Subject: 2026/91437 - Blacker Farm, Park Lane, Emley, Huddersfield, HD8 9QS

I have liaised with PROW team, and it advises that:

A	10.02.26	FIRST ISSUE
Rev.	Date	Description
Status		
PLANNING		
Client		
SAVILE ESTATE		
Project		
BLACKER FARM PARK LANE EMLEY HUDDERSFIELD, HD8 9QS		
Drawing Title		
PROPOSED ACCESS ROAD		
Scale (at A1)		Date
AS SHOWN		10.02.2026
Drg. no.		Rev.
340-25-PL03		A

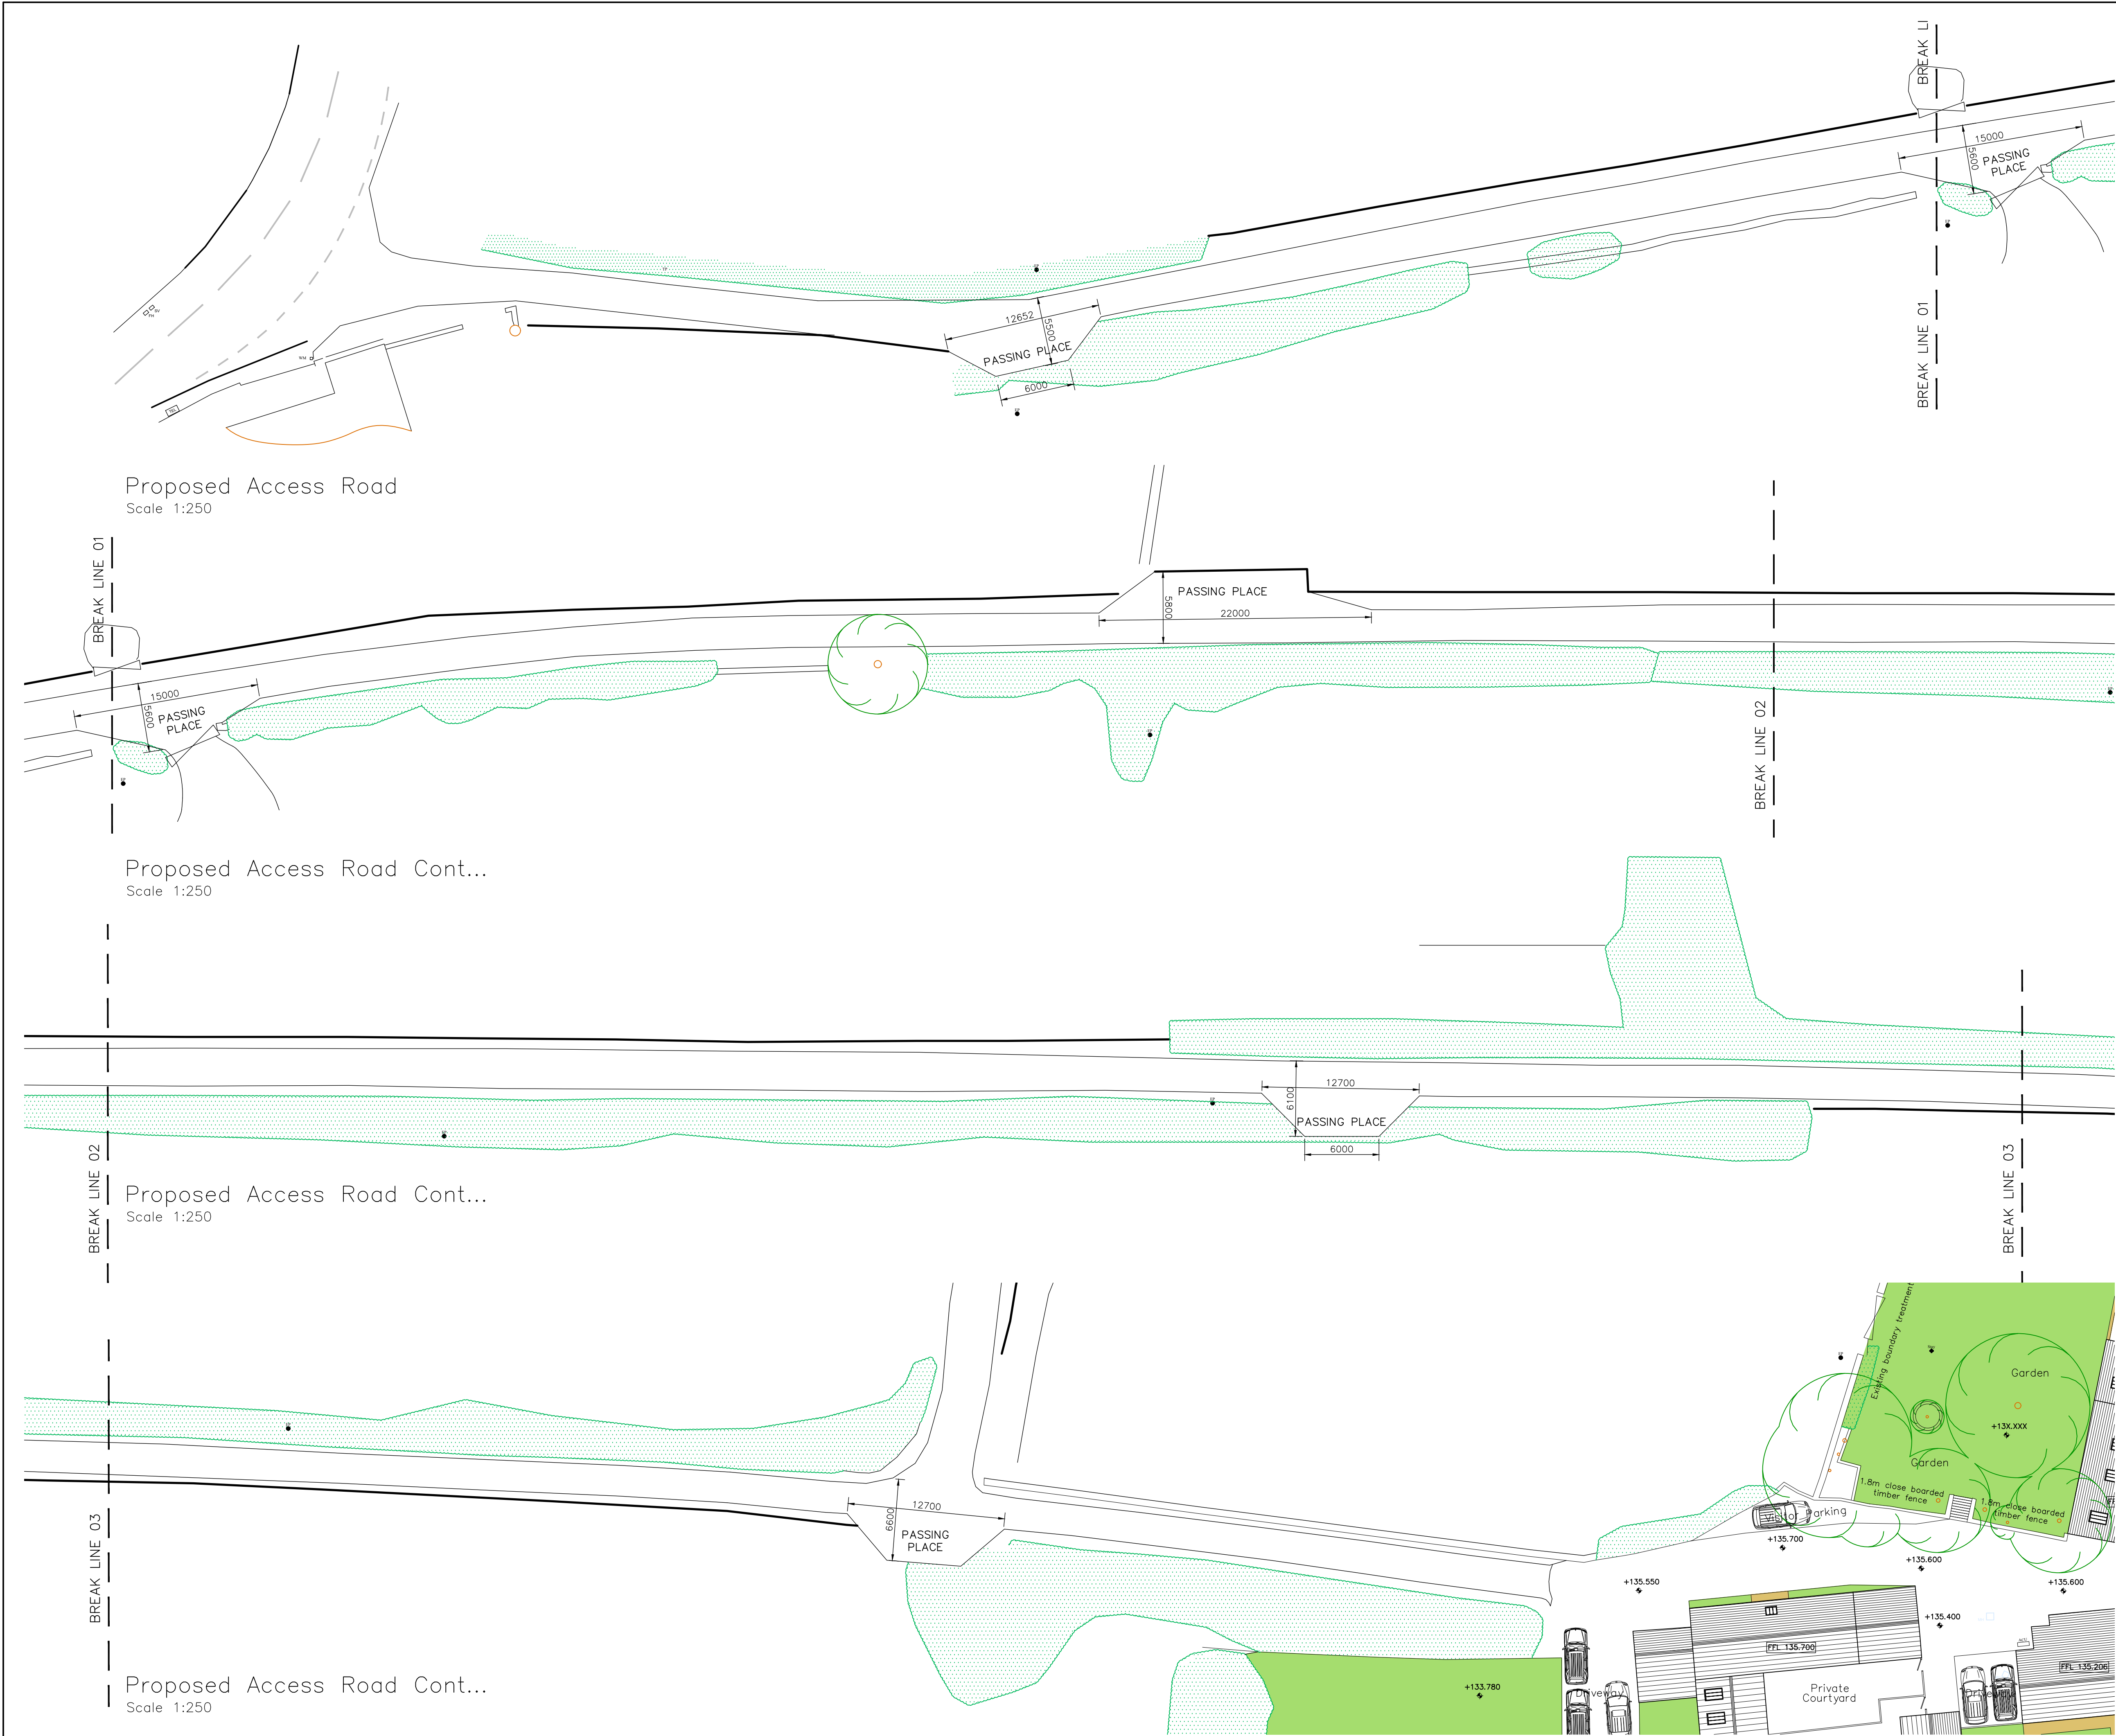
The access to the site is via Denby Dale 27 which is recorded as a public bridleway. No surfacing details is given for the passing places or the bridleway and are requested. PROW require written consent for any resurfacing and that a pre-commencement survey should be undertaken prior to any works starting, with assurances that any damage to the bridleway will be repaired by the developers via a planning condition.

The land to the south of the bridleway is at a lower height and request clarification on how this is to be accommodated or whether there is be enough flat ground available to allow vehicles, especially construction traffic to wait to allow other vehicular traffic to pass.

The final passing place nearest to the properties is at the same location as the footpath Denby Dale 26. Again, clarification is necessary on how this path is to be incorporated into the design and details are requested, including of the unrecorded step stile into the field since the land falls away. Additionally, if it can be confirmed if the land will continue to the farmed.
